Please ask for: Ms Iqraa Malik
Email: iqraa.malik@terraquest.co.uk
Telephone: 0121 234 1390
Our Ref: FG/35/22/HH
Your Ref:
Date: 28th February 2022

Application for Planning Permission for Works or Extension to a Dwelling

Development: Single storey front and rear extension and roof/attic extension.
Location: 9 Clover Lane Ferring BN12 5LZ

KEY PLAN AND SECTION 3-3	
9 CLOVER LANE	
FERRING WEST SUSSEX	
DATE NOV 2021	
DRAWING BY JG.	SCALE 1:50
	1:100
	1:200
No 9.B	1:10

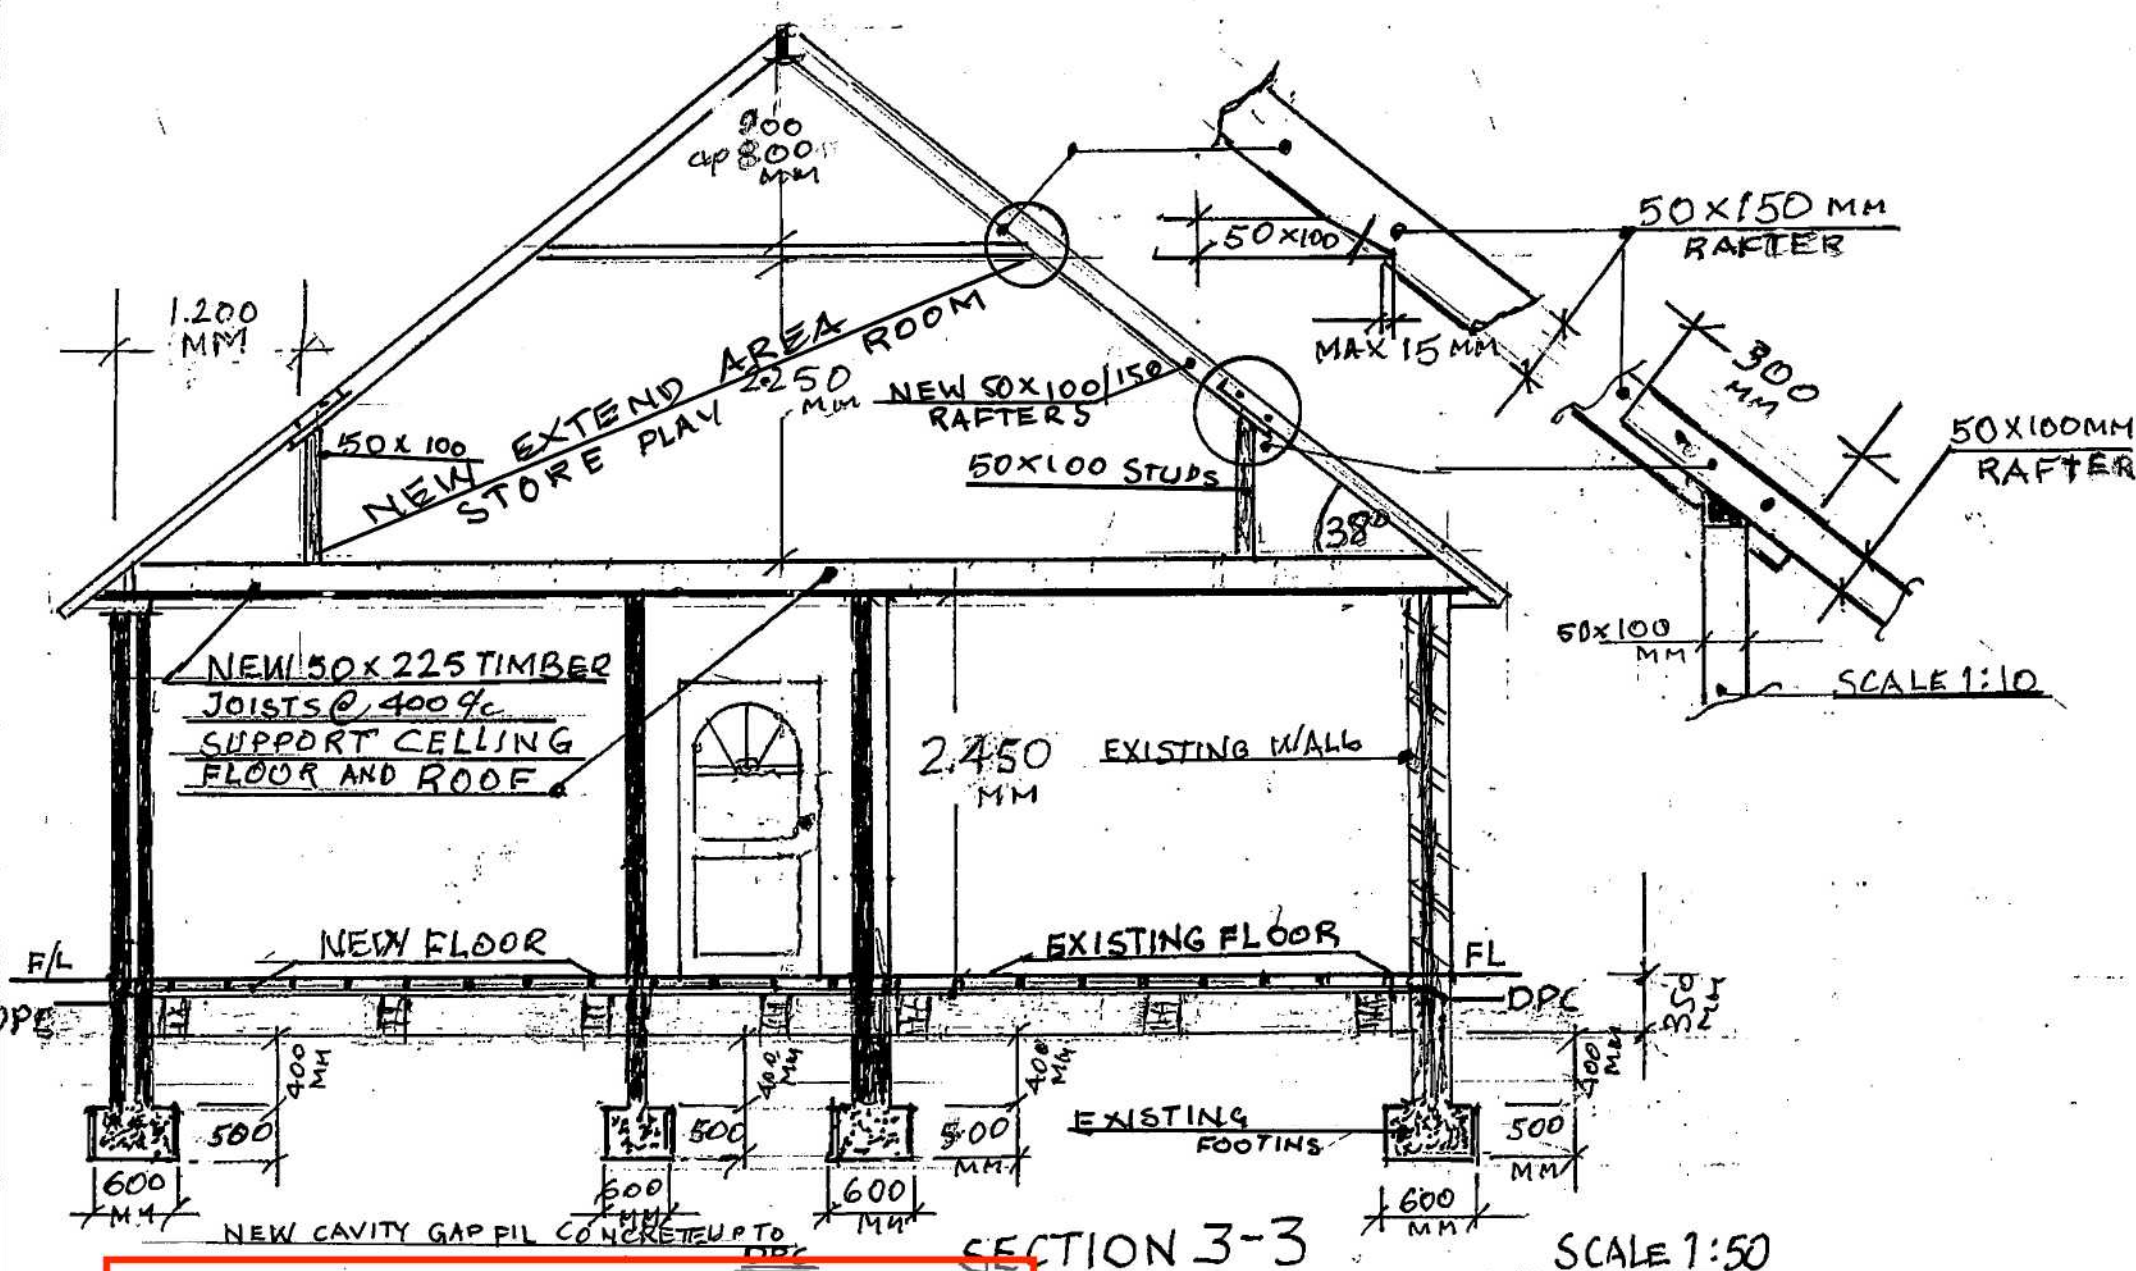
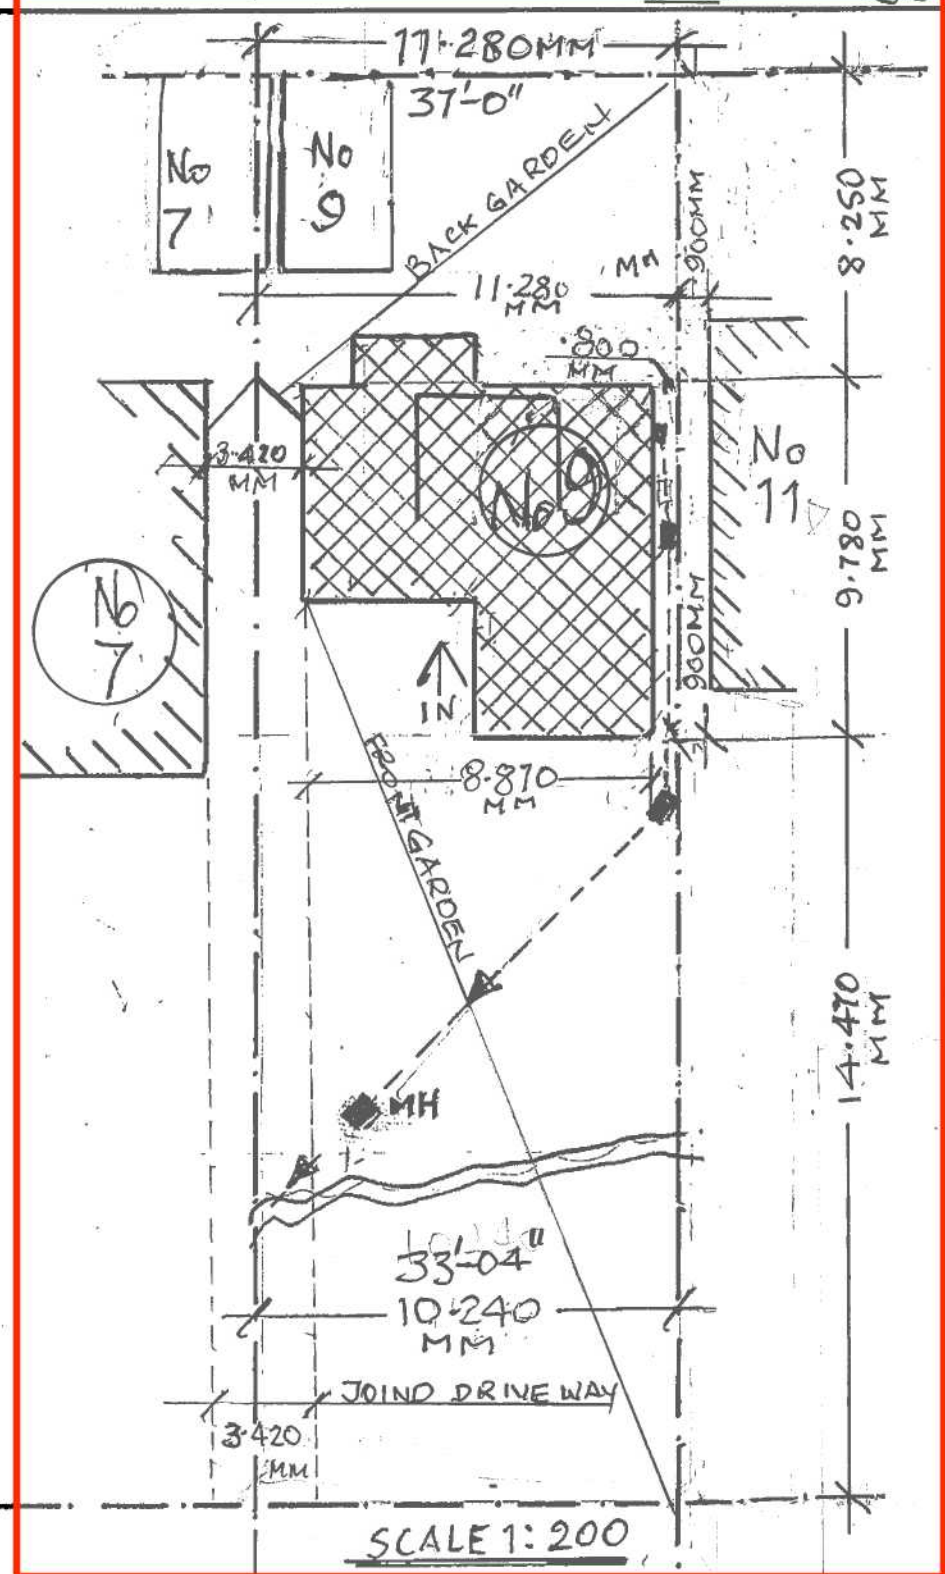
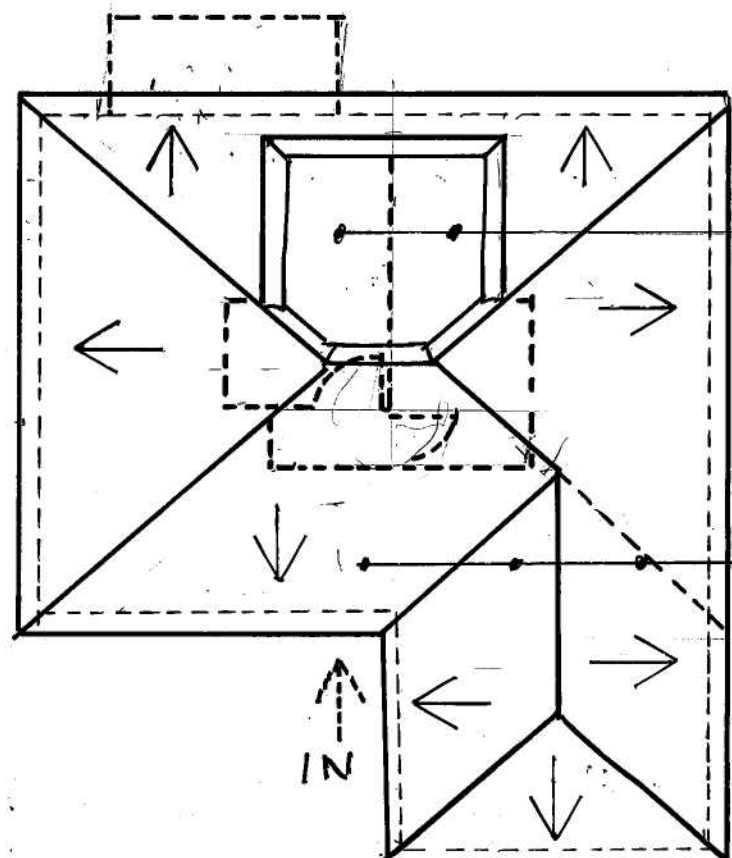
Dimensions: You are required to include dimensions on the block plan from the proposed extension to all site boundaries

Scale Bars: You are required to include scale bars on all plans. Please amend
